Application by Highways England for an Order Granting Development Consent for the A303 Sparkford to Ilchester Dualling Project

Examining Authority's request for further information

The Examining Authority refers to your submission in relation to the drainage ponds date 7 June 2019.

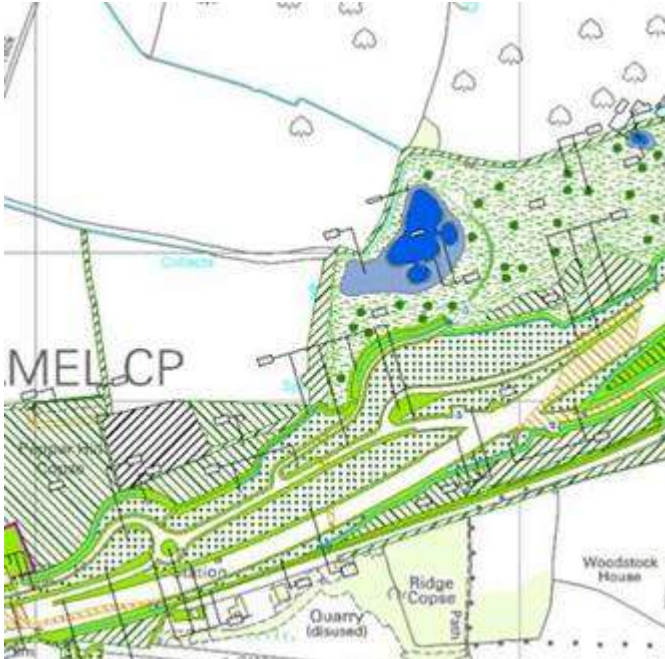
It is noted that you consider the size and depth of the proposed ponds to be satisfactory. Notwithstanding this, the Examining Authority would appreciate an indication of the maximum acceptable size (either in terms of area or dimensions) and depths considered appropriate for such ponds.
